KITTITAS COUNTY FIRE MARSHAL'S OFFICE

July 8, 2016

Re: Bailey (BL-16-00009)

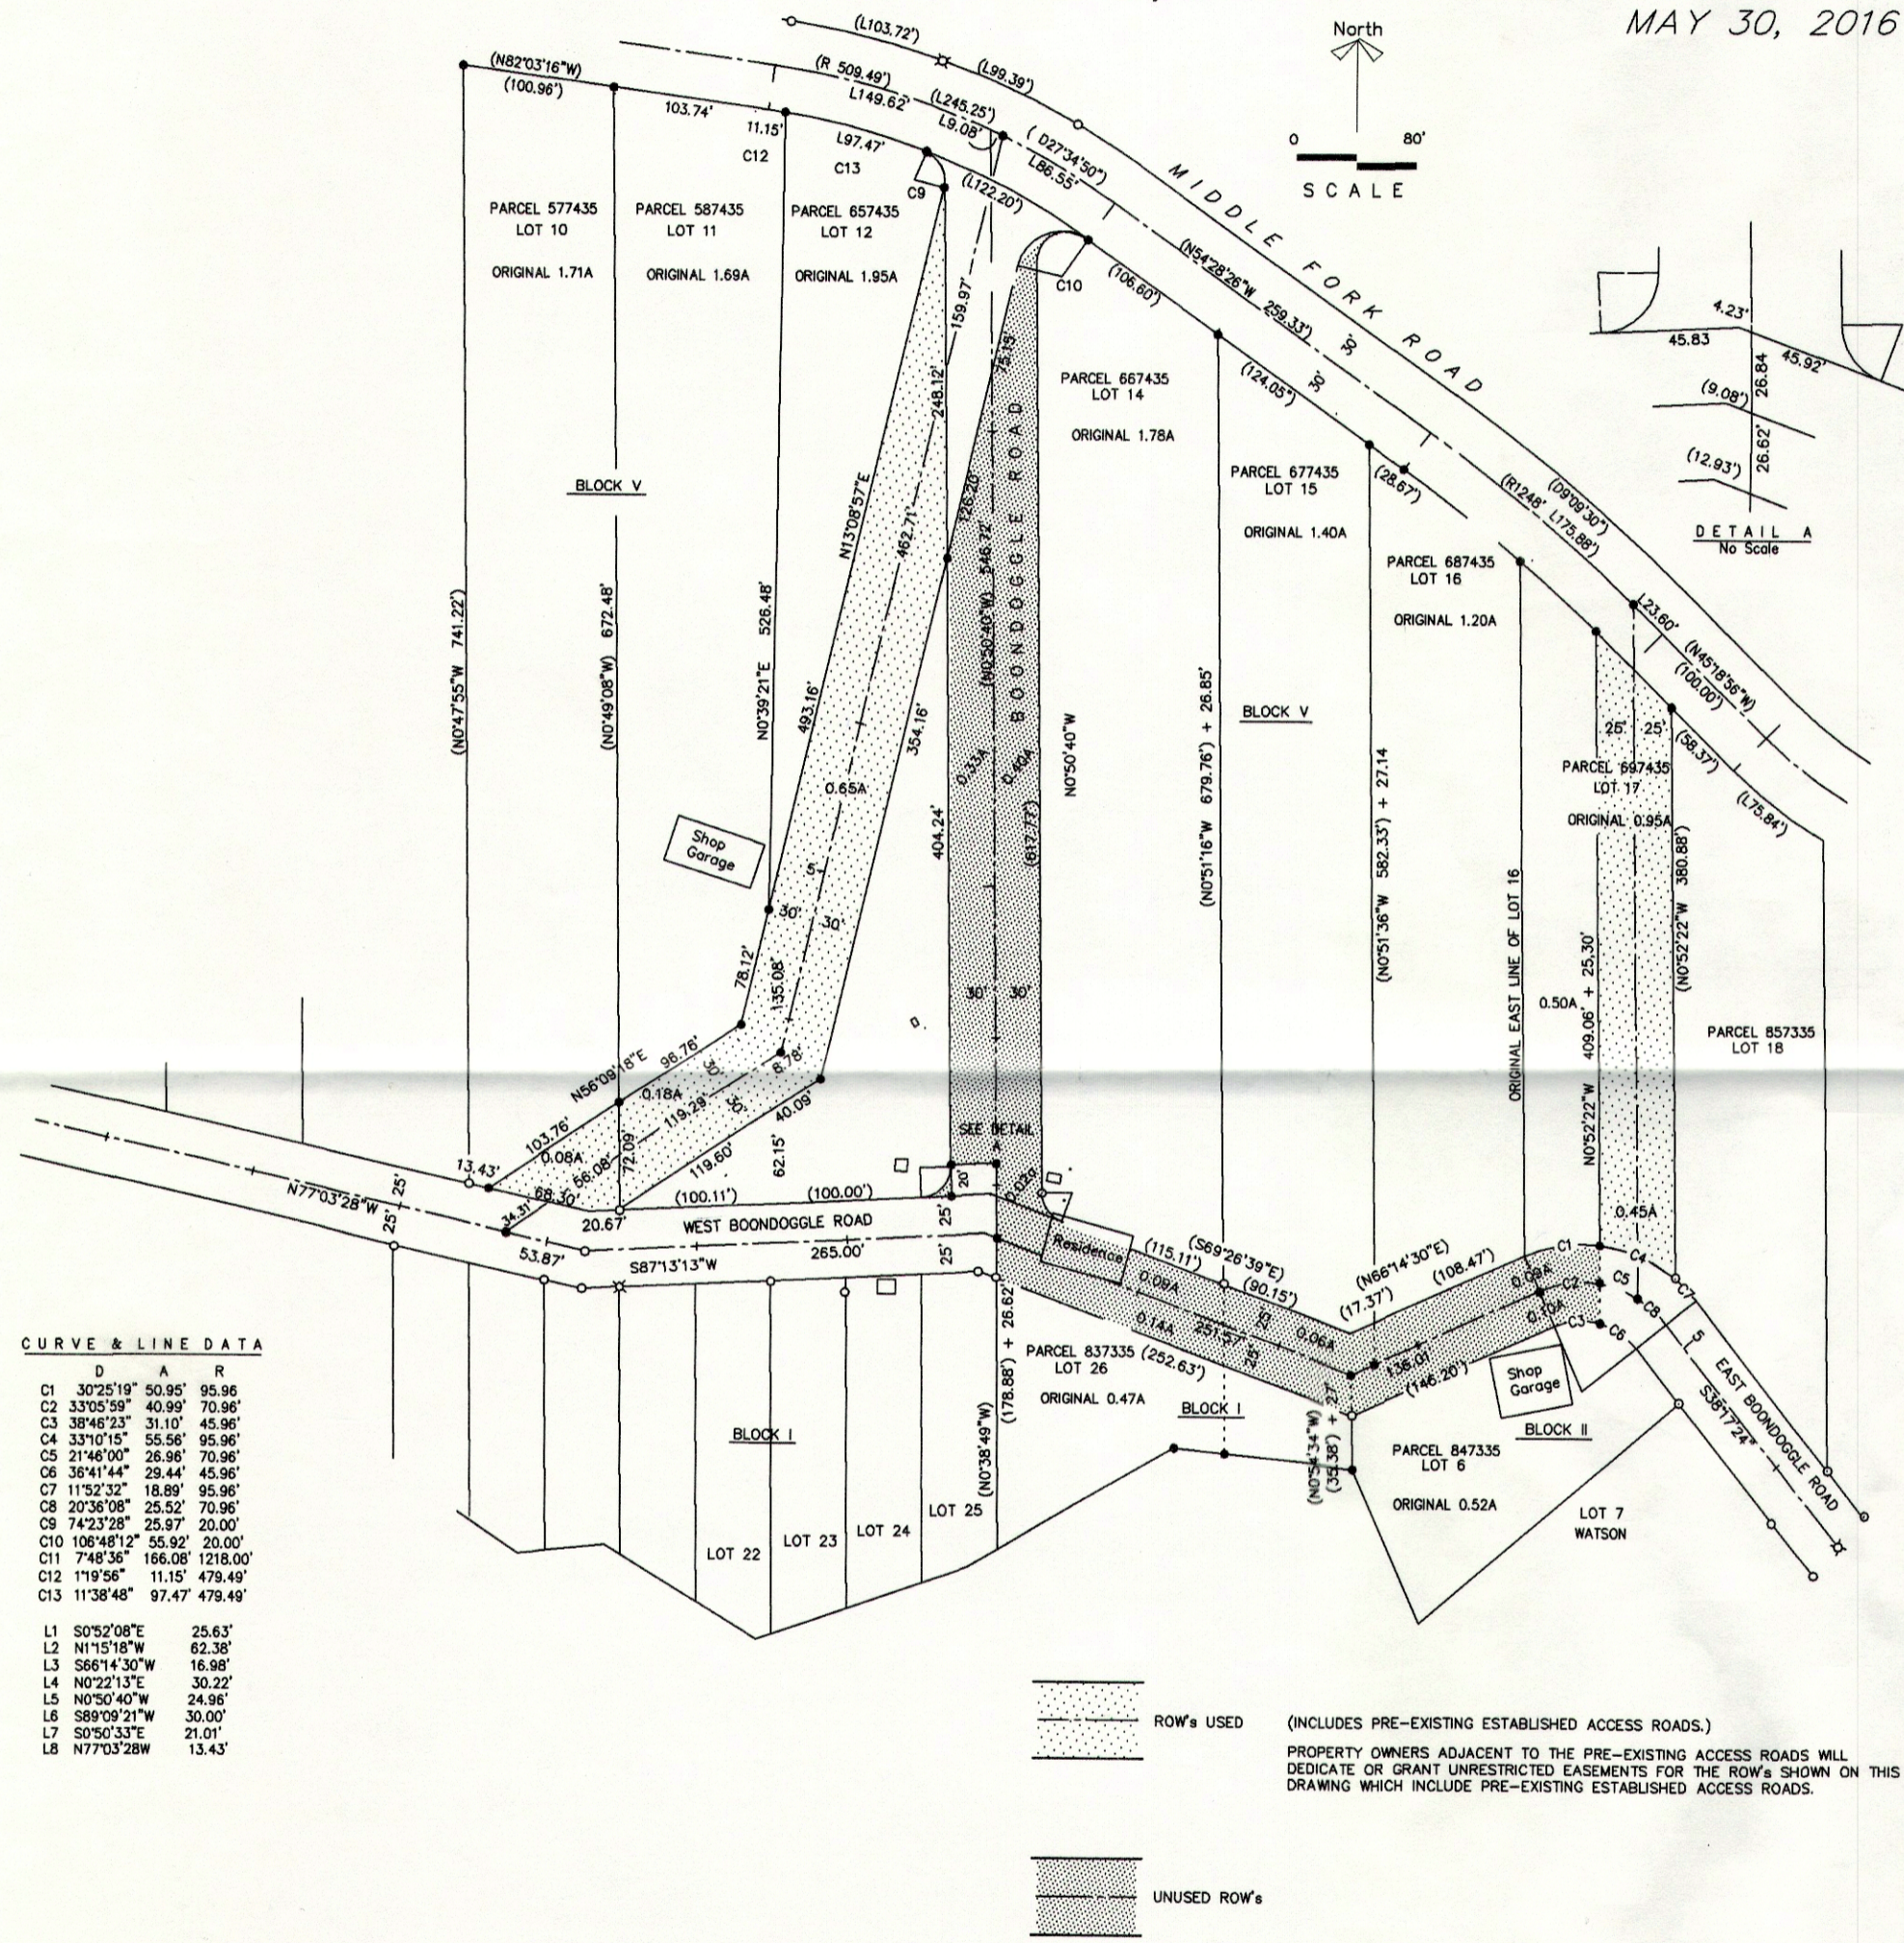
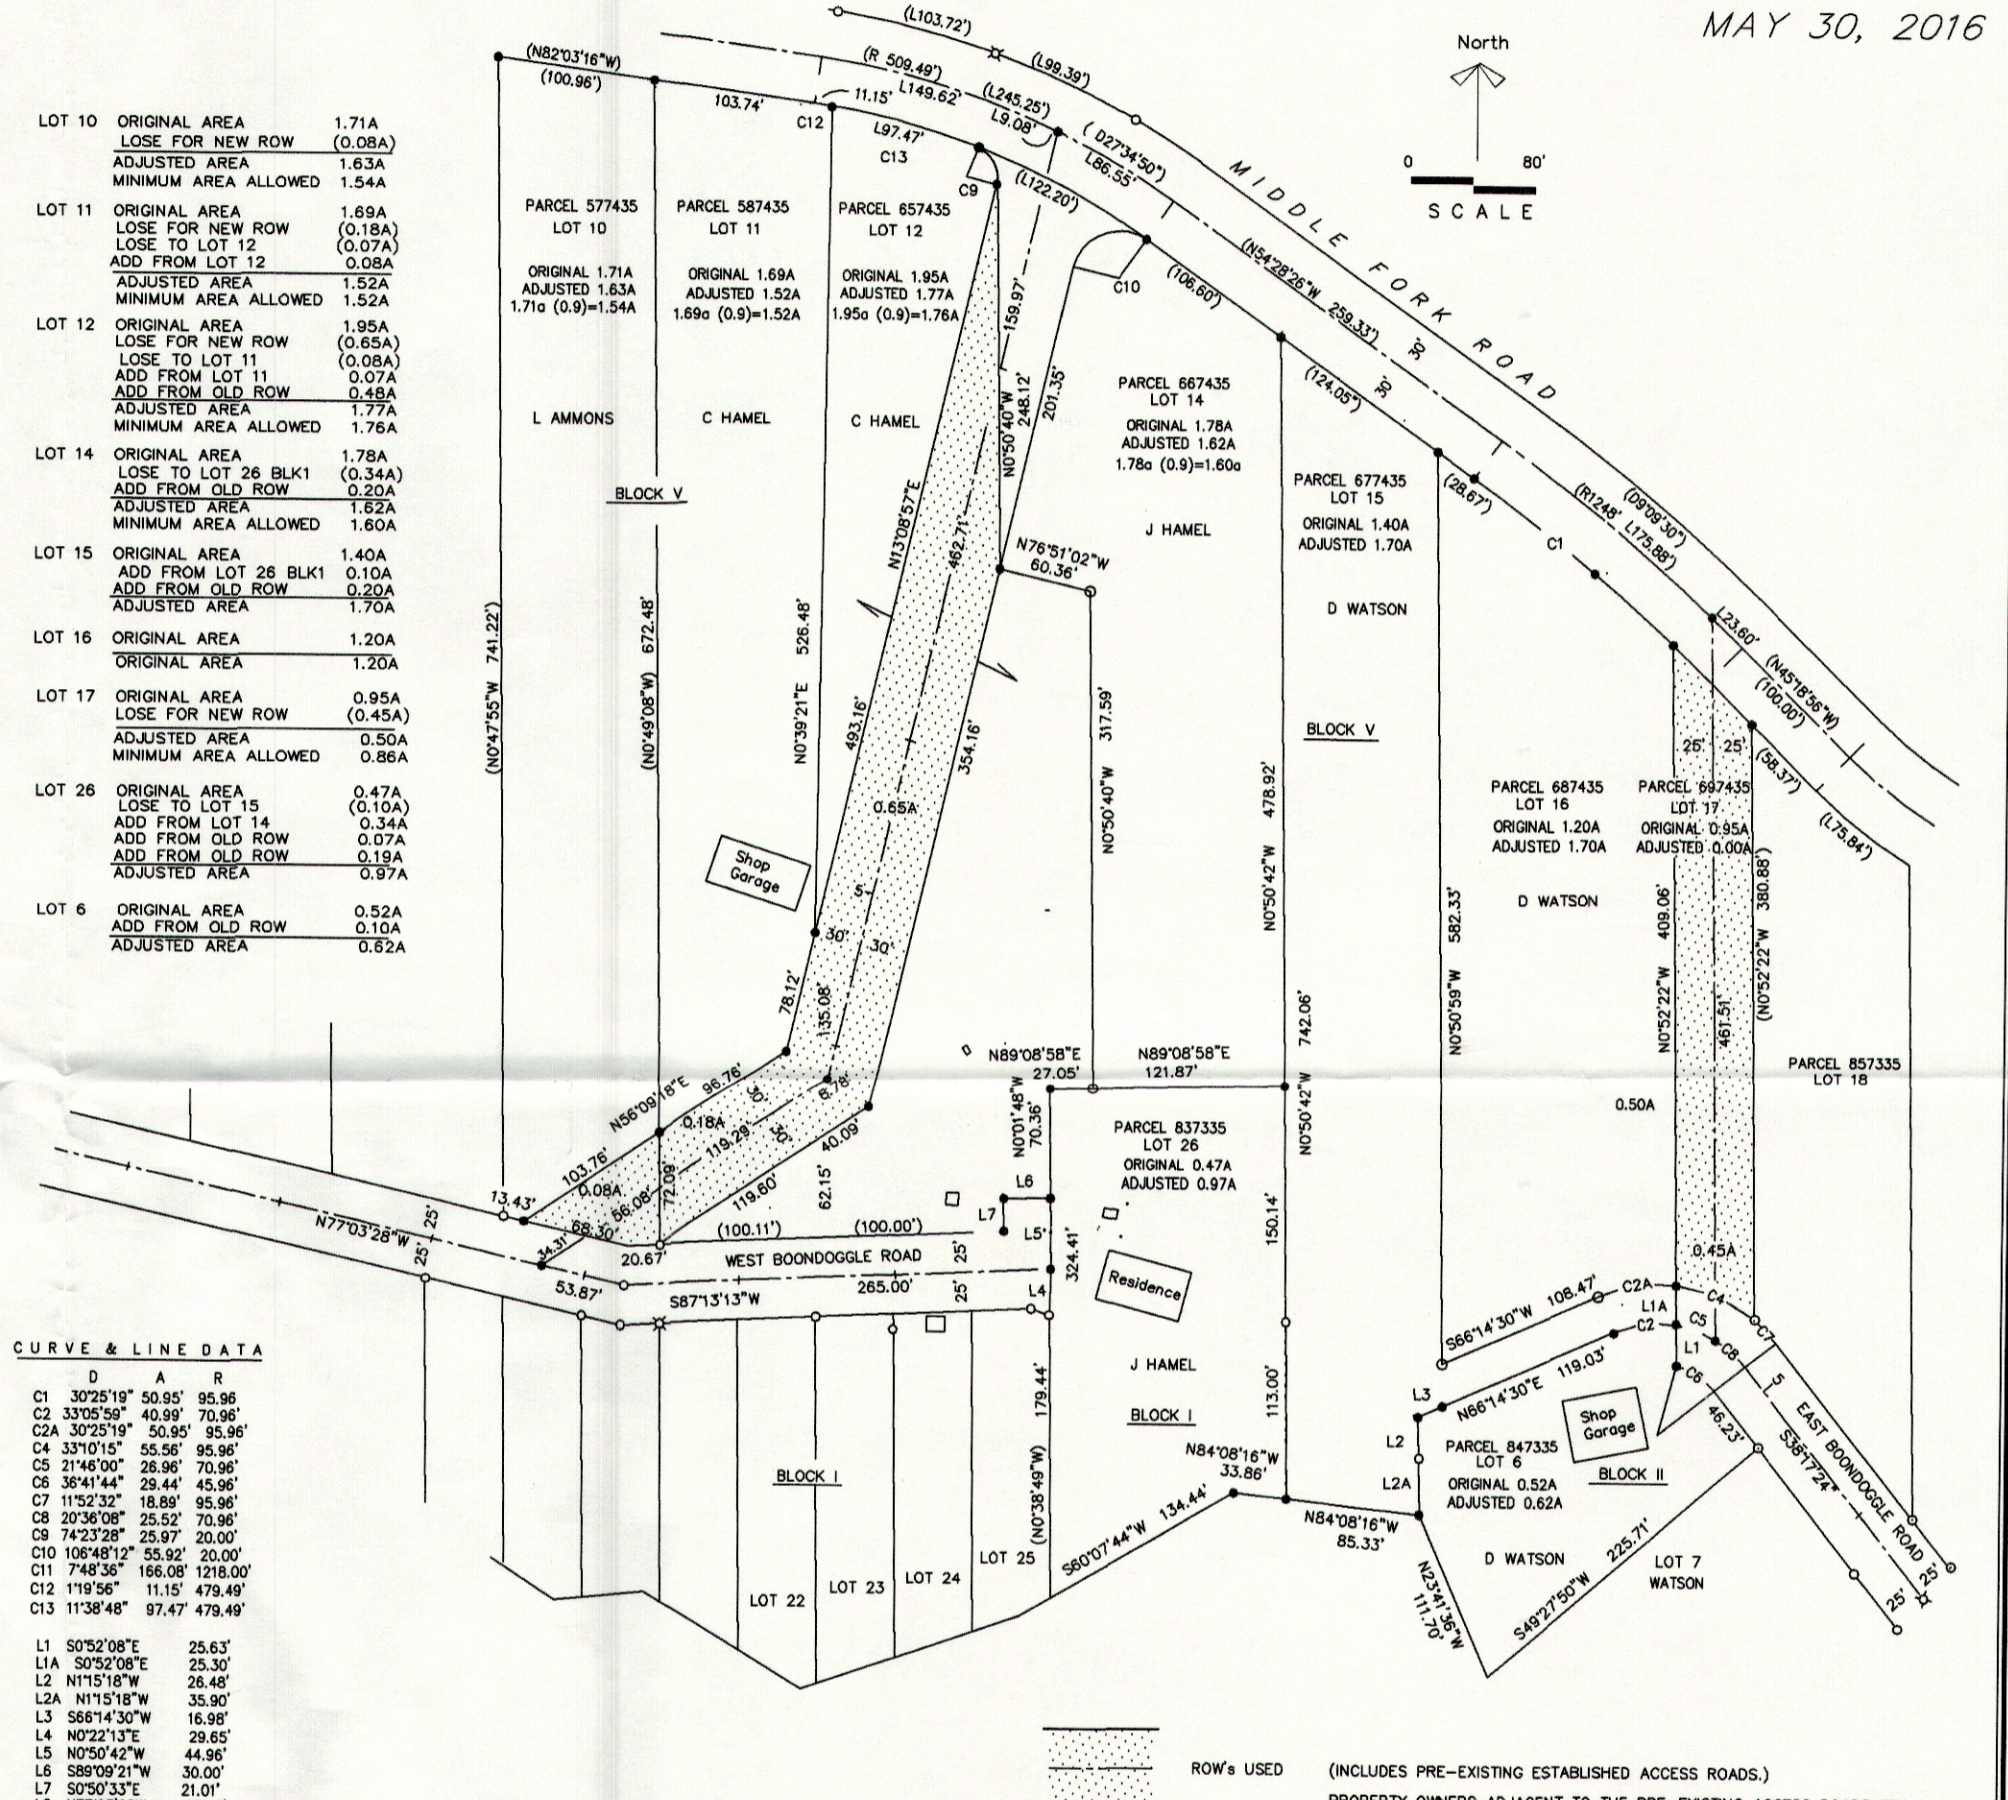
- Ensure that boundary line adjustments do not infringe upon existing structures, to include propane tanks, etc.
- Ensure adequate access for fire apparatus. Any driveways or access points created based off the new lot configurations shall comply with Kittitas County Code 20.02.030.
- All future development must comply with the International Fire Code.
